KITITITAS COUNTY

MEMORANDUM

TO: All Staff
FROM: Public Works Planning Review Team
DATE: March 17, 2020
SUBJECT: BL-20-00008 Ogg

The Public Works Department has reviewed the Request for Boundary Line Adjustment Application. In order to ensure that it meets current Kittitas County Road Standards, the applicant needs to provide the following prior to final approval:

BOUNDARY LINE ADJUSTMENT BL-20-00008

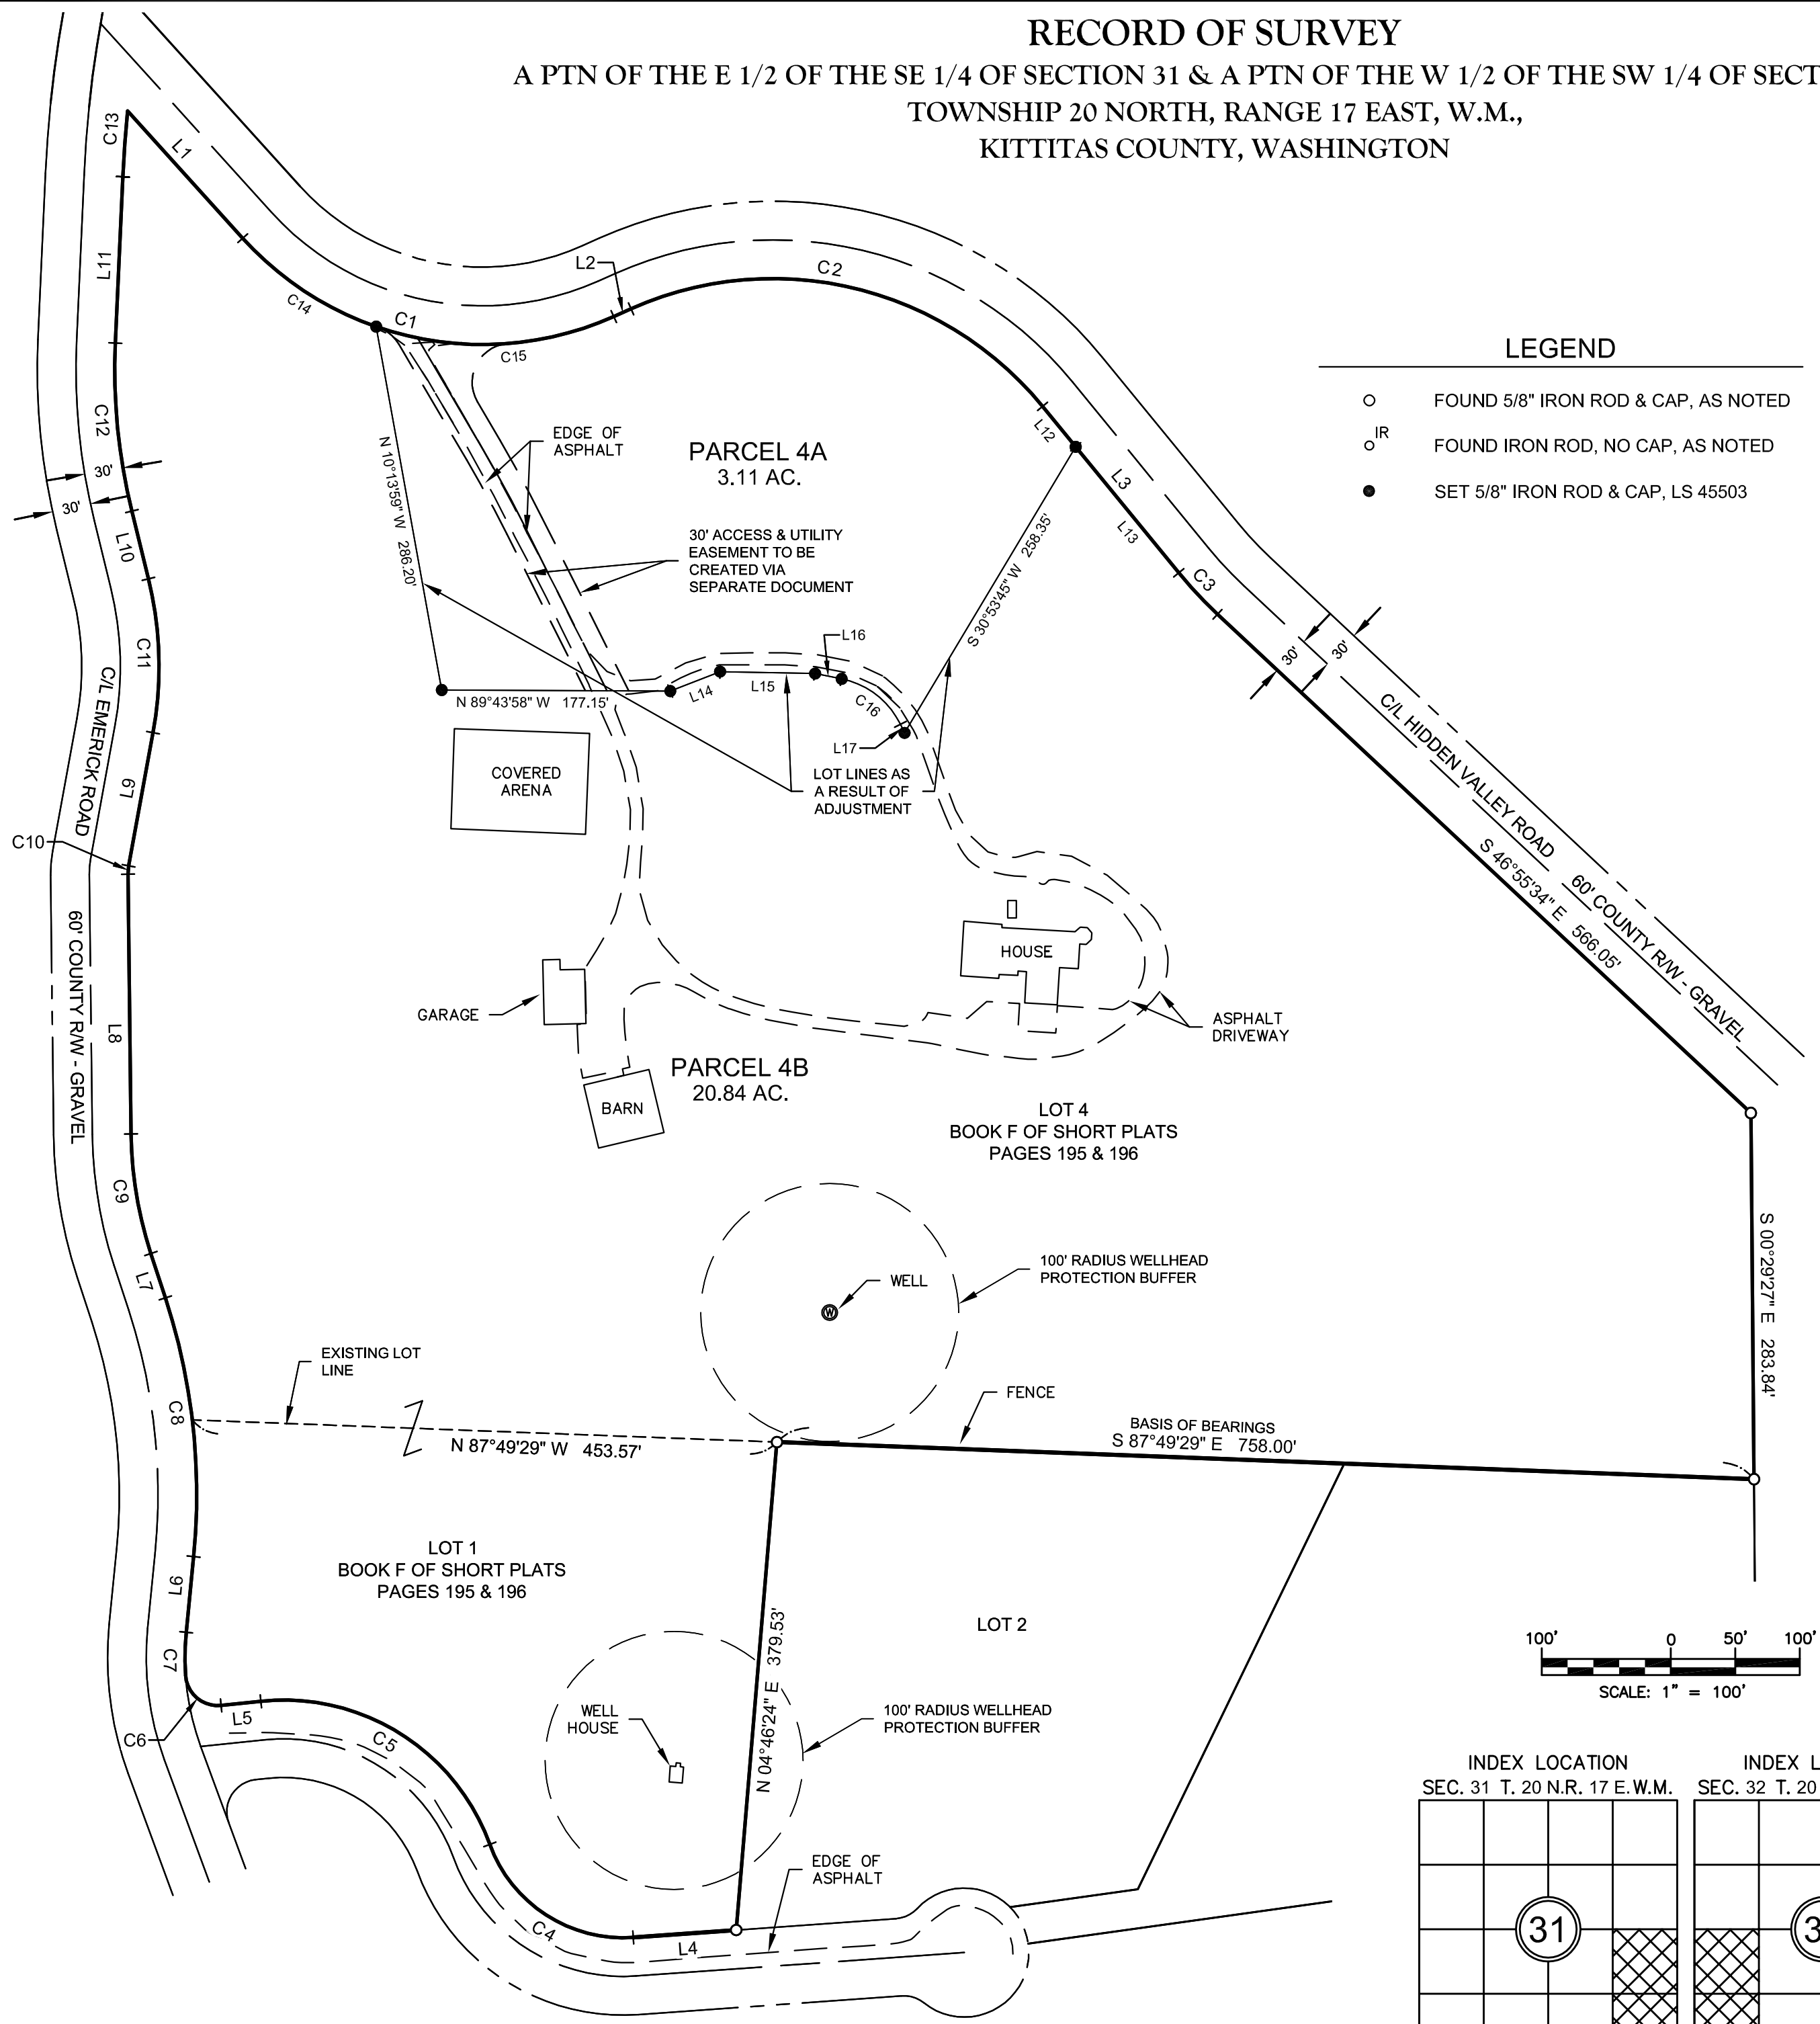
1. The Survey Map is missing the following information:
 - a. Legend
 - b. Survey control utilized for setting corners
 - c. Basis of Bearing
 - d. Purpose of survey statement
 - e. Surveyors statement
 - f. Auditors statement
 - g. Equipment and procedures statement
2. Emerick Road should include ownership, surfacing and width.
(ex: 60' County R/W – Paved)
3. Hidden Valley Road should include Ownership and surfacing
(ex: County R/W – Paved)

4. The access easement on the final survey should be changed to "30' access and utility easement to be created via separate document", OR record the easement just prior to recording the survey, and write in the easement recording number (preferred).
